File Ref: EXT/2023/0001

### **SSD-10371-Mod 4- Trinity Grammar School**

Thank you for providing Council with the opportunity to comment on the proposed modification for the development at Trinity Grammar School

2808-DA150.pdf

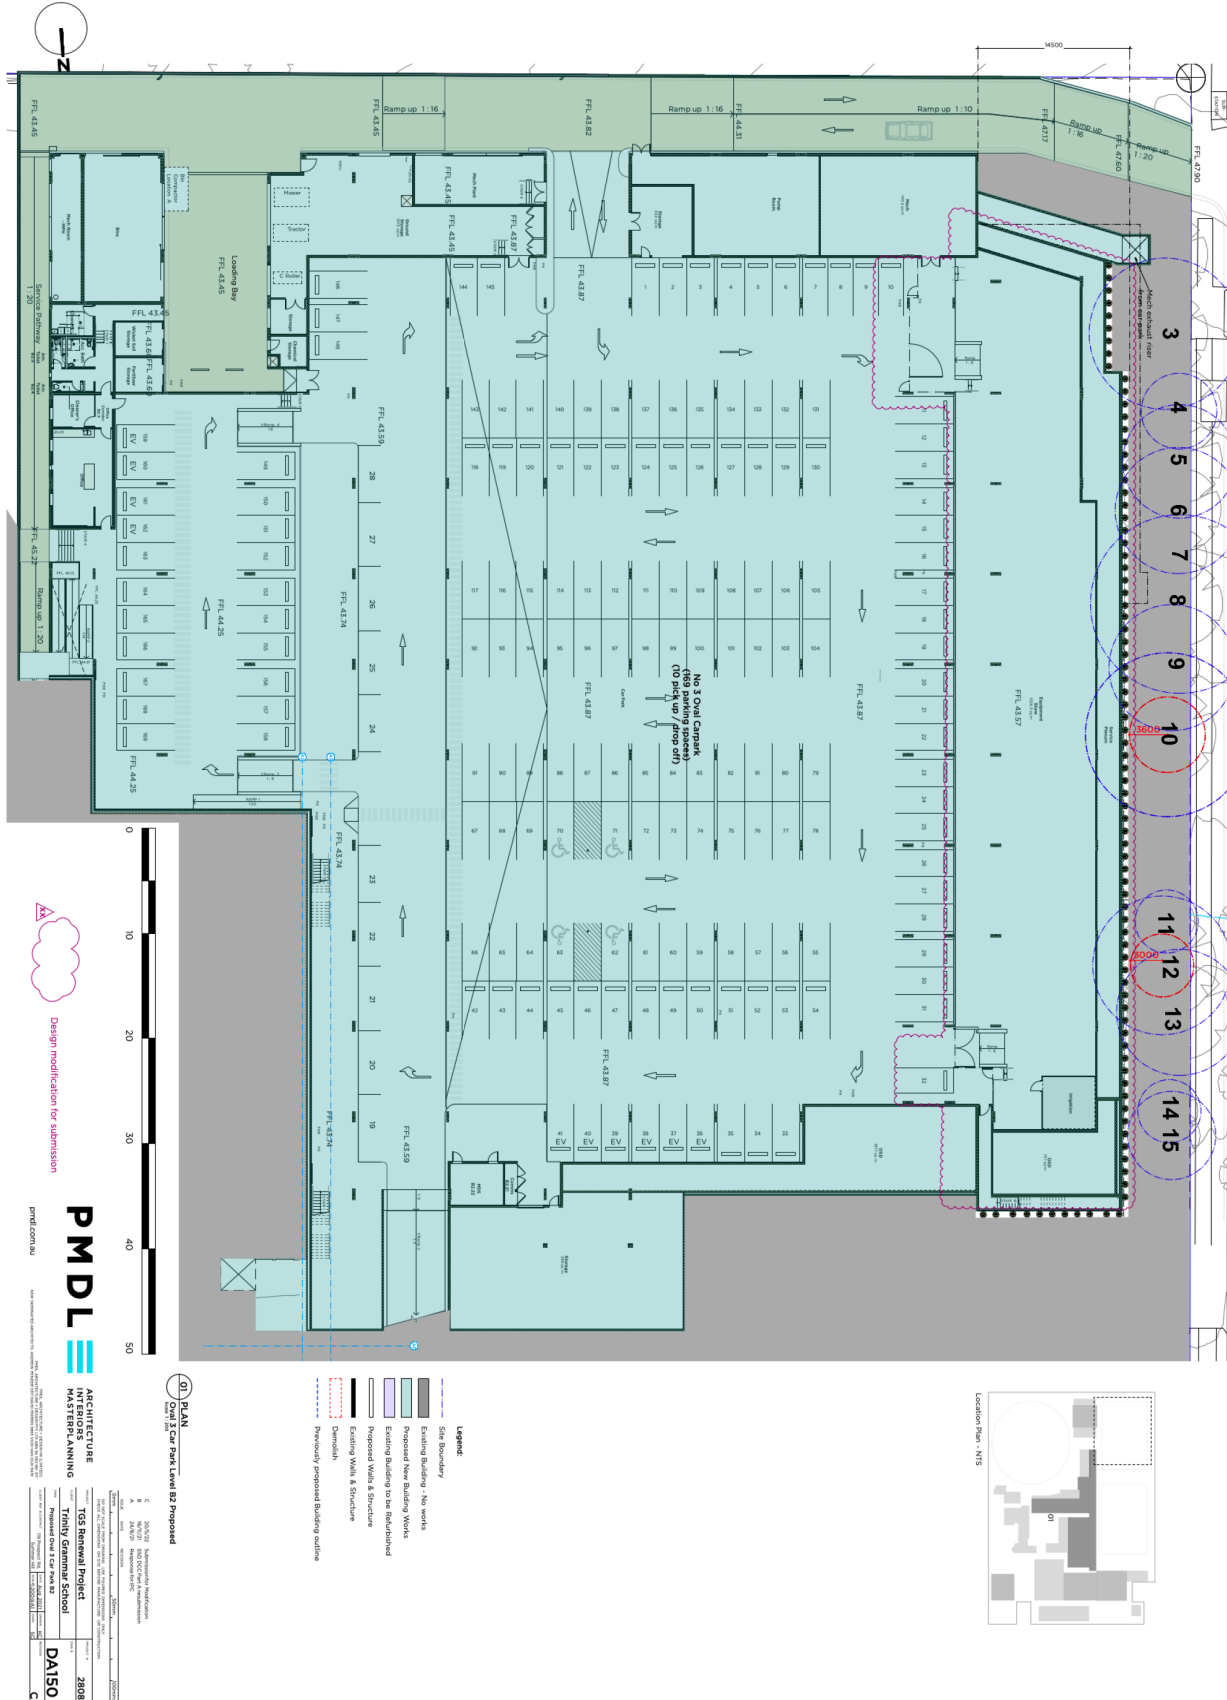
In particular concern is raised regarding the impact the proposed extension of the basement would have on the trees on the western boundary of the site. It is considered the incursion of the proposed basement to the structural root zones of the affected trees is not sufficient to mitigate the impact to their viability and health.

Whilst it is noted that that an Arboricultural Impact Addendum dated 15 November 2022, prepared by Meredith Gibbs of Australis Tree Management has been submitted for review and comment, it appears that the author may not have been to site (work appears to have started between May and August of 2022). In this regard, in order to provide accurate advice, an updated assessment is required.

A visual inspection from the front of the site carried out on 12 January 2023 reveals that there are trees in decline as a result of the works that have already been carried out. I would urge you to request the applicant provide an amended Arboricultural assessment report that reflects the current state of the site, and if there are any trees that have been impacted by the works, that adequate conditions are imposed for the remaining trees to retain their viability and additional conditions are imposed for replacement planting to compensate for the trees that have been damaged and are no longer viable as a result of the works carried out.
